Meeting note

Project name	East Midlands Gateway Phase 2 and East Midlands Gateway Rail Freight Interchange Material Change
Case reference	BC0410001 and TR0510002
Status	Final
Author	Planning Inspectorate
Date of meeting	30 September 2025
Meeting with	SEGRO Properties Ltd and SEGRO (EMG) Ltd
Venue	Microsoft Teams
Circulation	All attendees

East Midlands Gateway 2 DCO application

Section 51 advice for applicant relating to documentation as to submission dated August 2025

# ES Chapter Study Area Figure (Core Assessment)

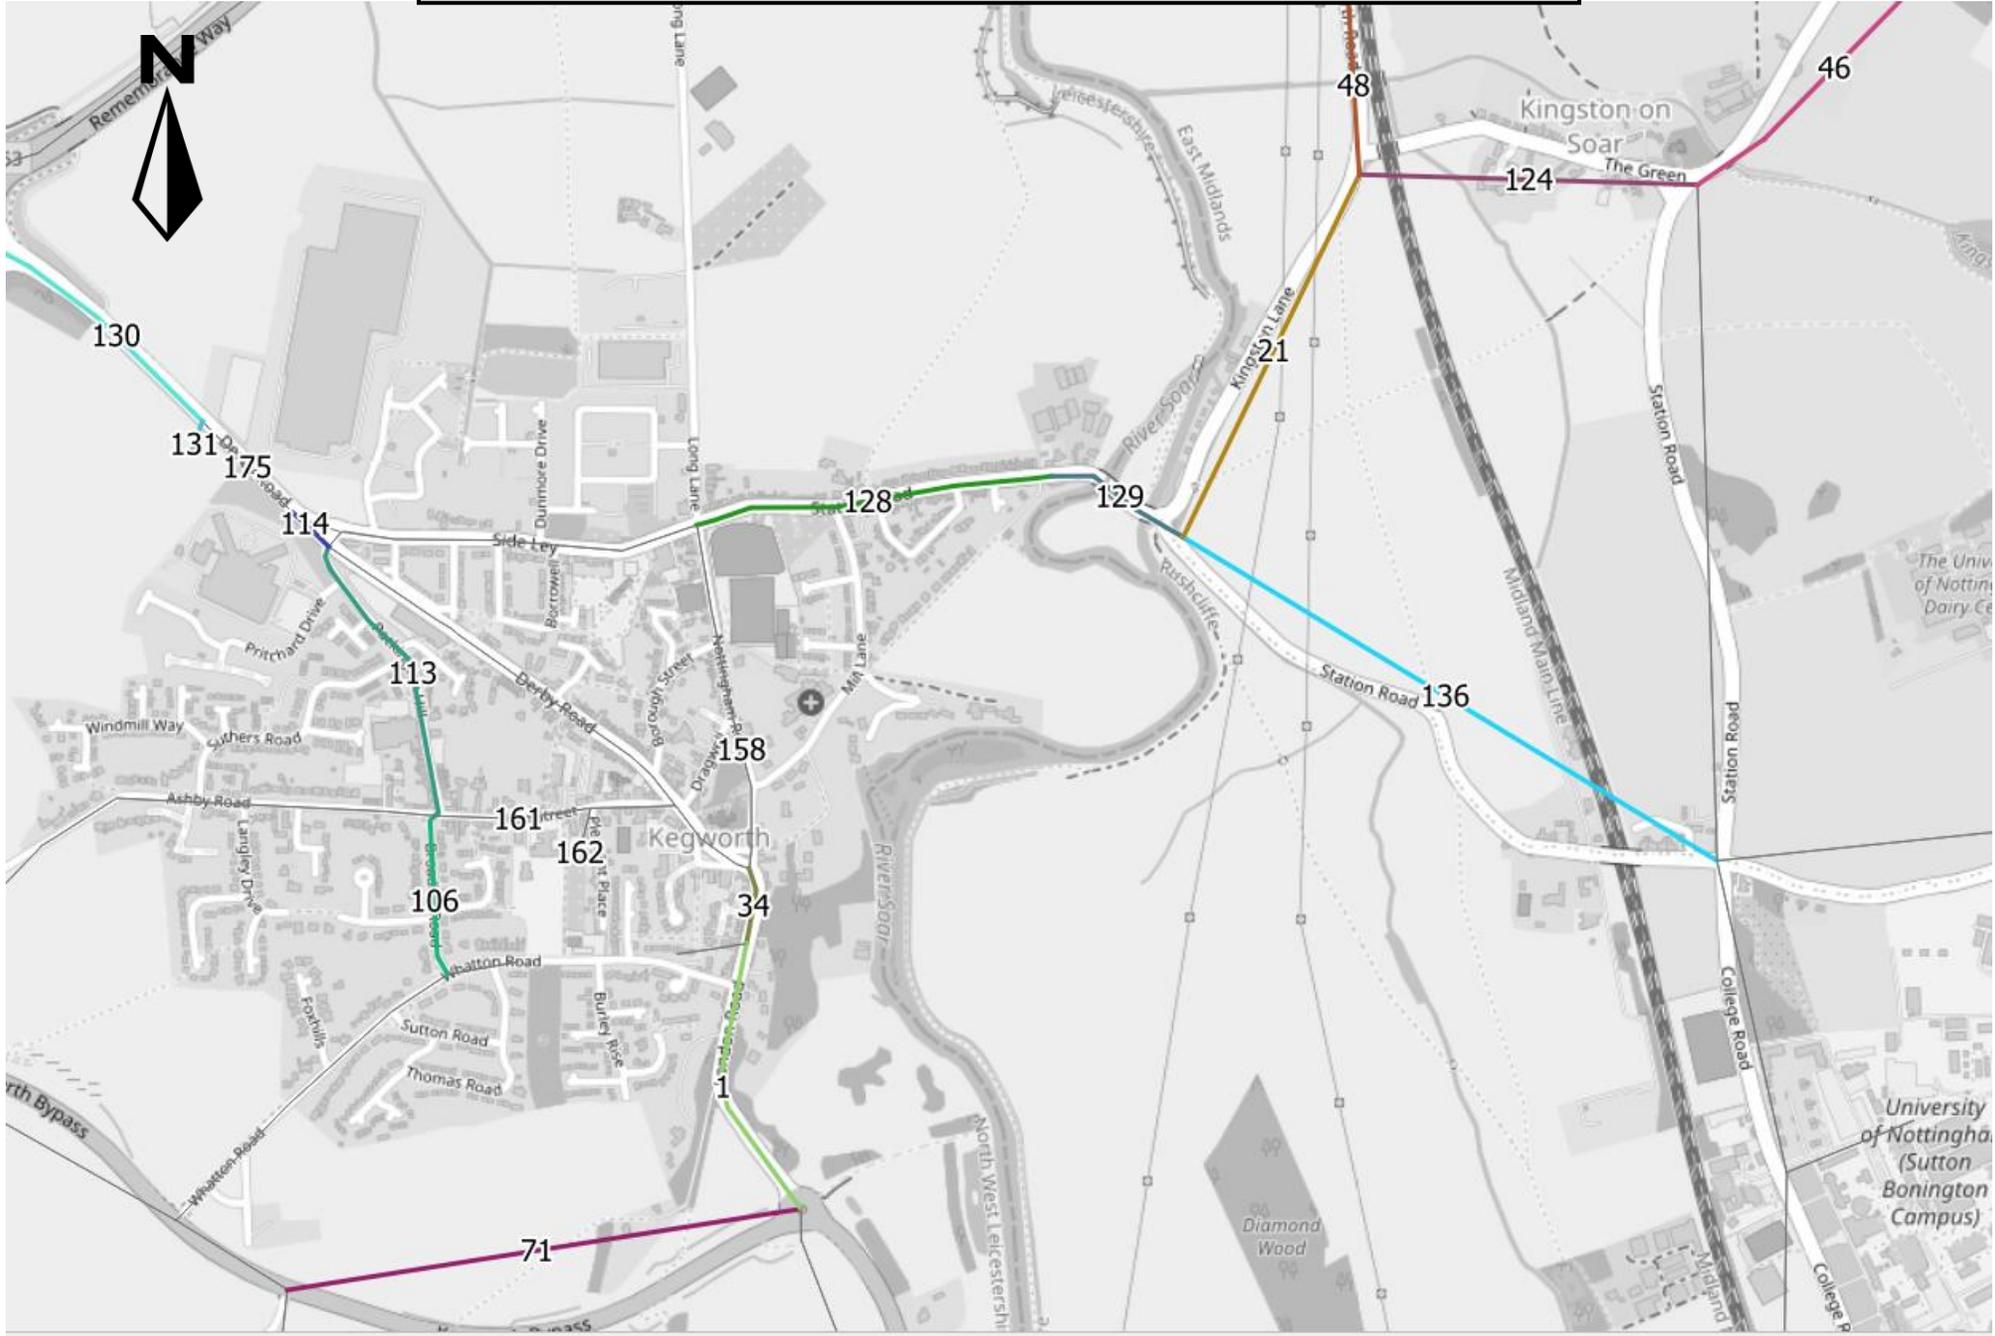
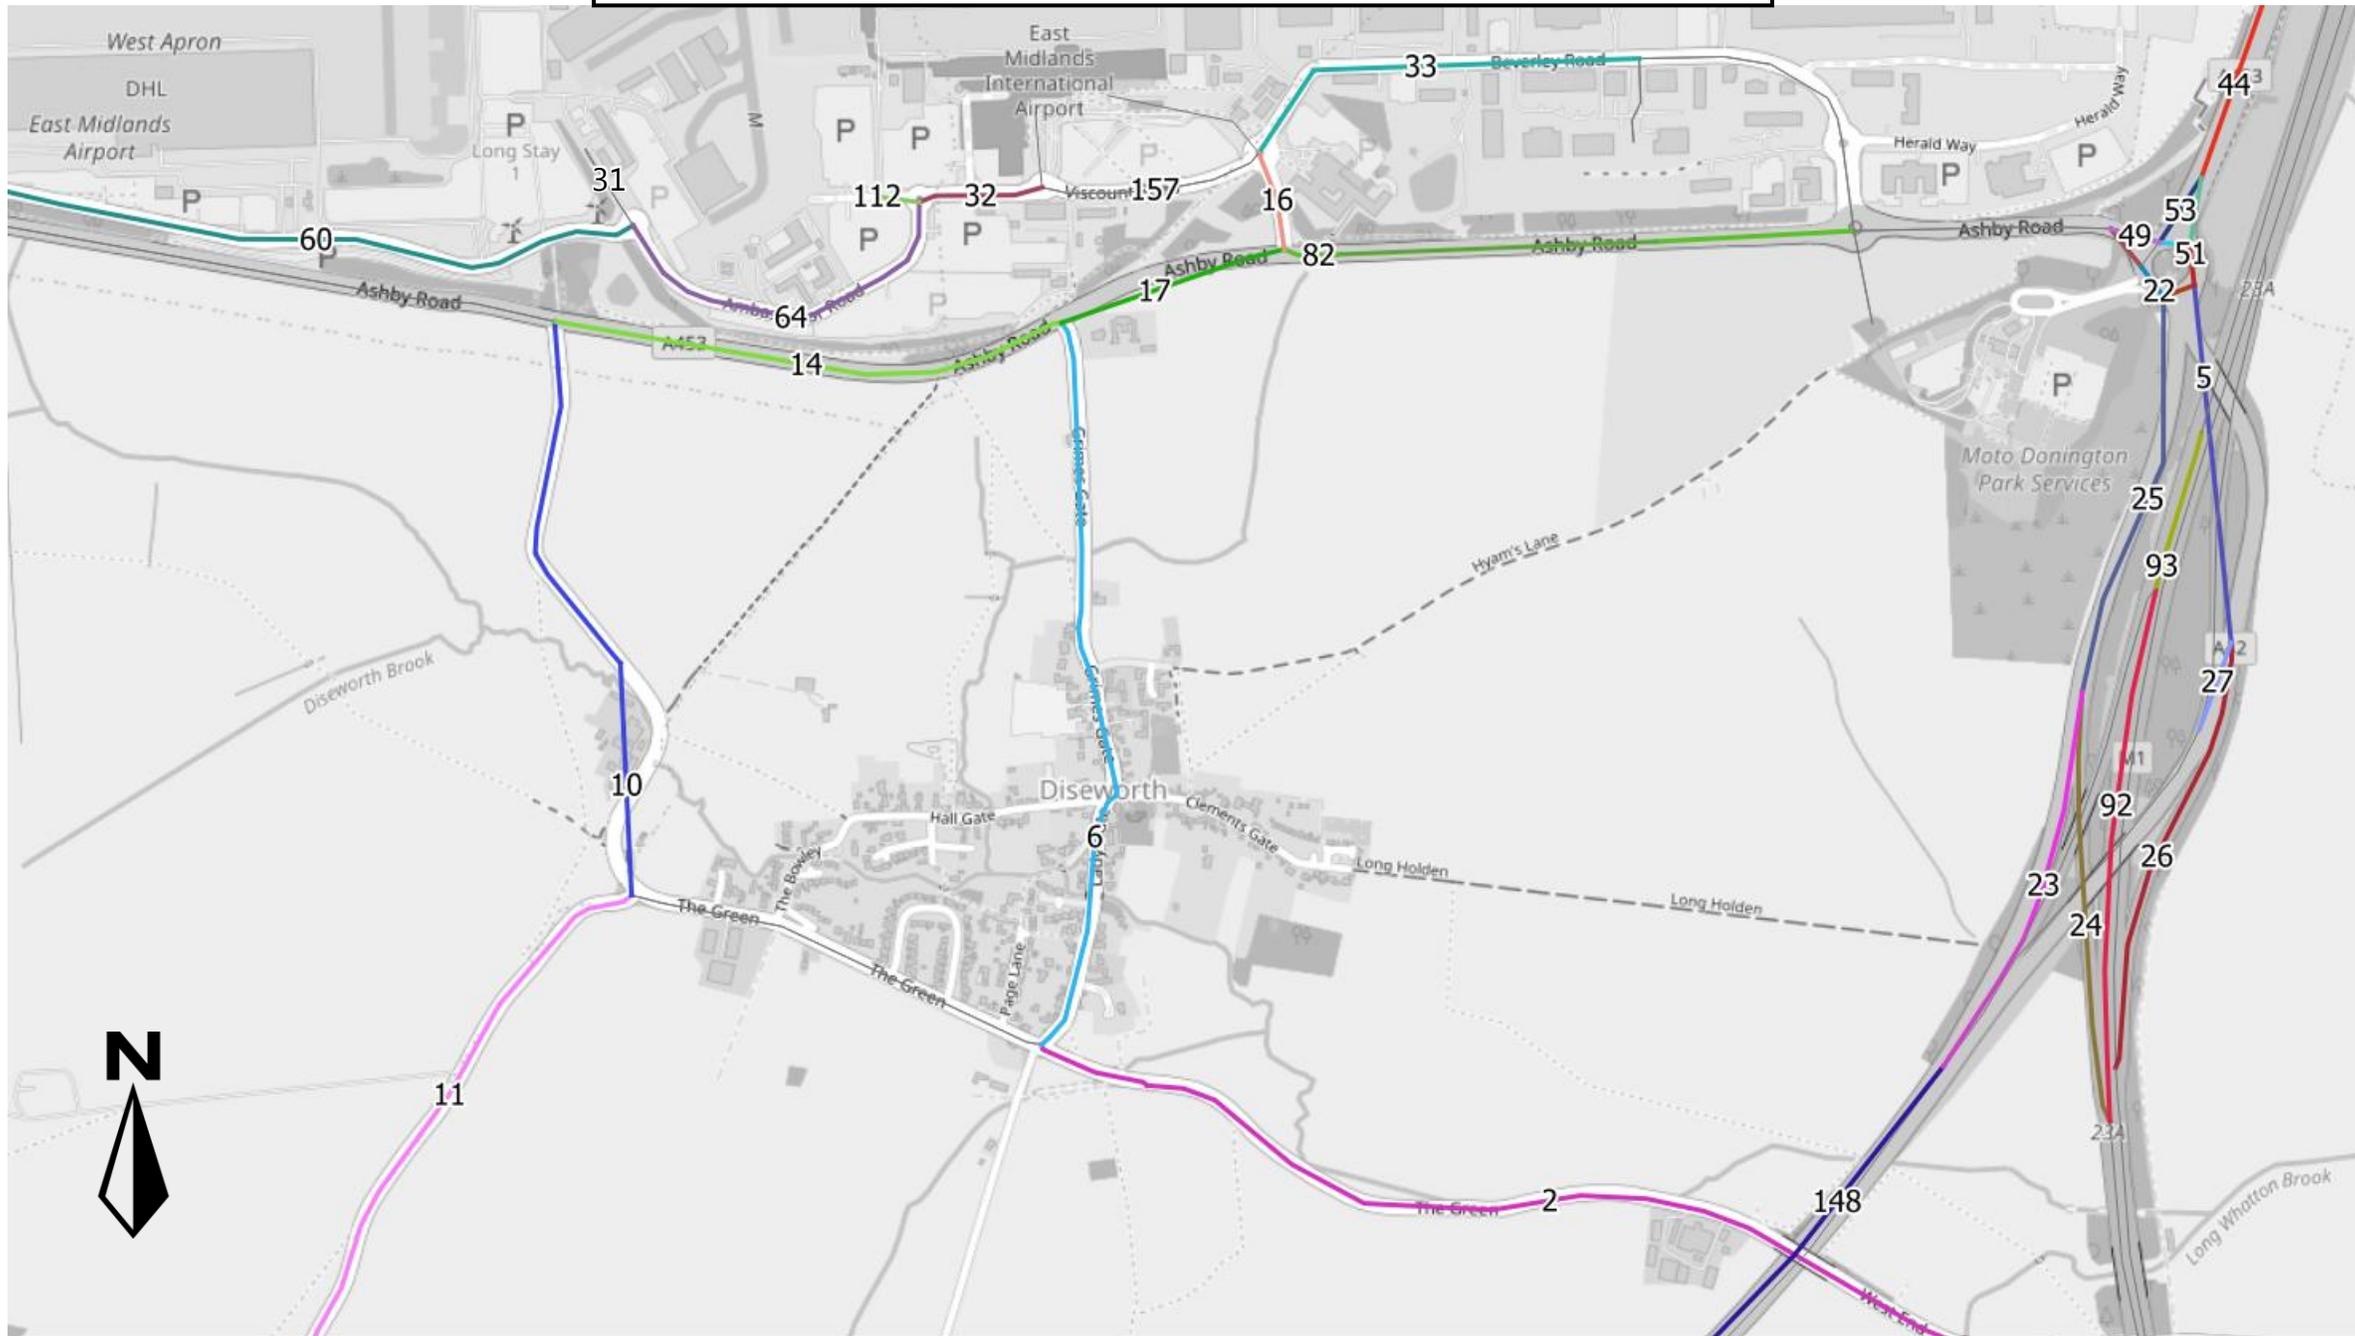
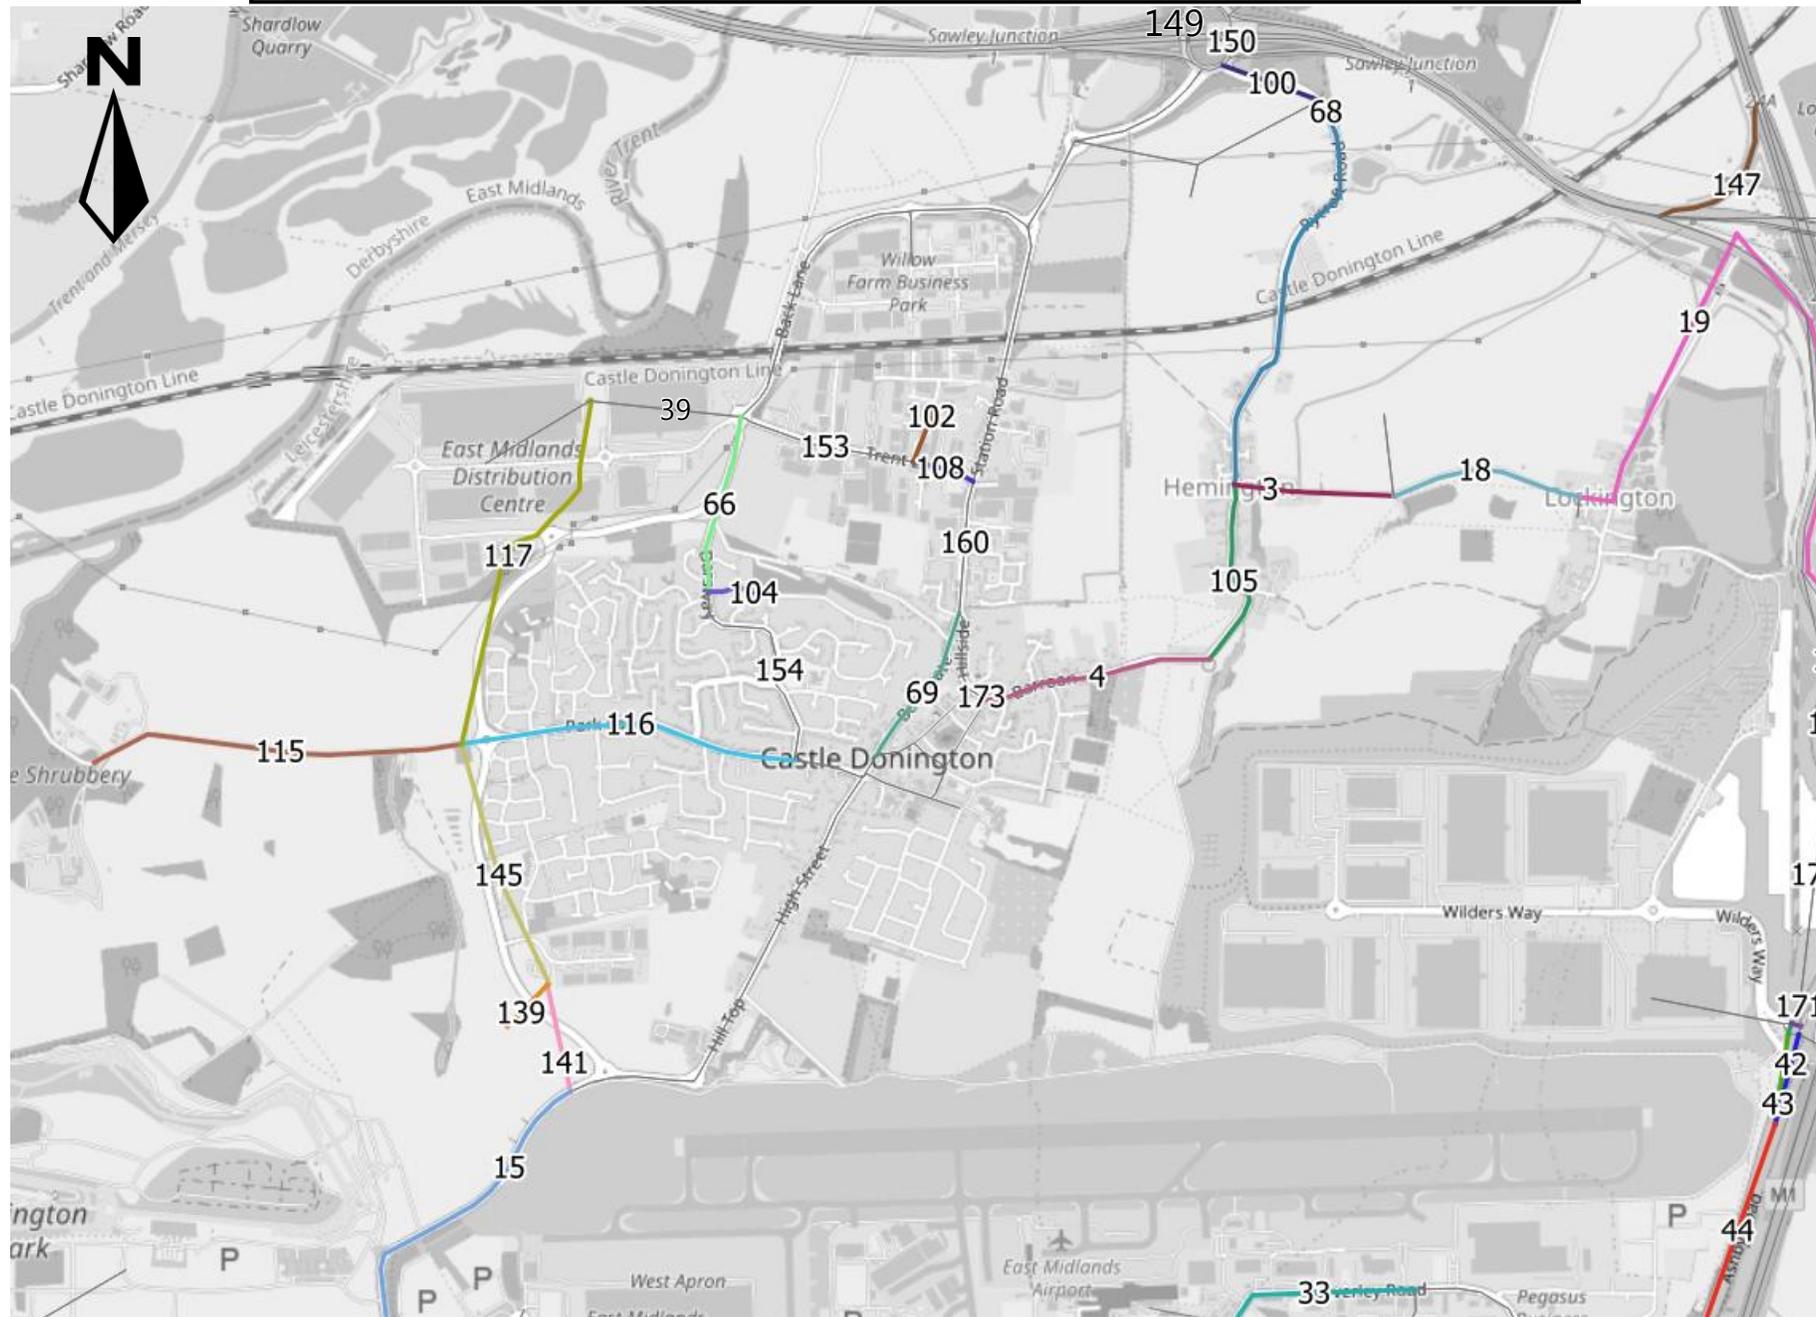
The Inspectorate identified within the transport assessment (TA), and also Chapter 6 of the Environmental Statement (ES), references to routes / links, however the precise location of these is not clear.

Issue	Potential Resolution
<u>Transport Assessment</u>		
1.	<p>Within the Transport Assessment (TA) and chapter 6 of the Environmental Statement (ES) there are numerous routes/ links which are referred to. However, it is not clear the precise locations of these or the extent of the routes/ links.</p> <p>Examples include:</p> <ul style="list-style-type: none"> • Tables 25, 26, 28, 29 and 30 of the TA • Paragraph 6.6.9 of chapter 6 of the ES refers to various links, purporting to show them in a figure in Appendix 6D. However, Link 6 is said to be Long Street, Belton which is not shown. There is a link “6” in Diseworth (given there isn’t a link “9” this may be upside down). The extent of link 28 also is not clear, and Link 54 (see Table 6.8) appears to be missing from Appendix 6D, and there are two links identified as ‘Link 20’ in the key. • Tables 6.9 and 6.14 of chapter 6 of the ES. <p>Furthermore, Tables 25 and 26 of the TA have as their first column titles ‘Counter location’ but all are times.</p>	<p>Provide plans based on Ordnance Survey at no greater scale than 1:10 000 showing full extent of all links referred to. This may involve redrafting documents such as chapter 6 of the ES, its appendices and the TA, to ensure all routes/ links are fully identified. Ensure tables have appropriate identifiers.</p>

The applicant explained that it shall refine this information into smaller segments and provide further clarity regarding the 172 links identified. The Inspectorate noted that the applicant should make this information clear and comprehensible for all stakeholders.
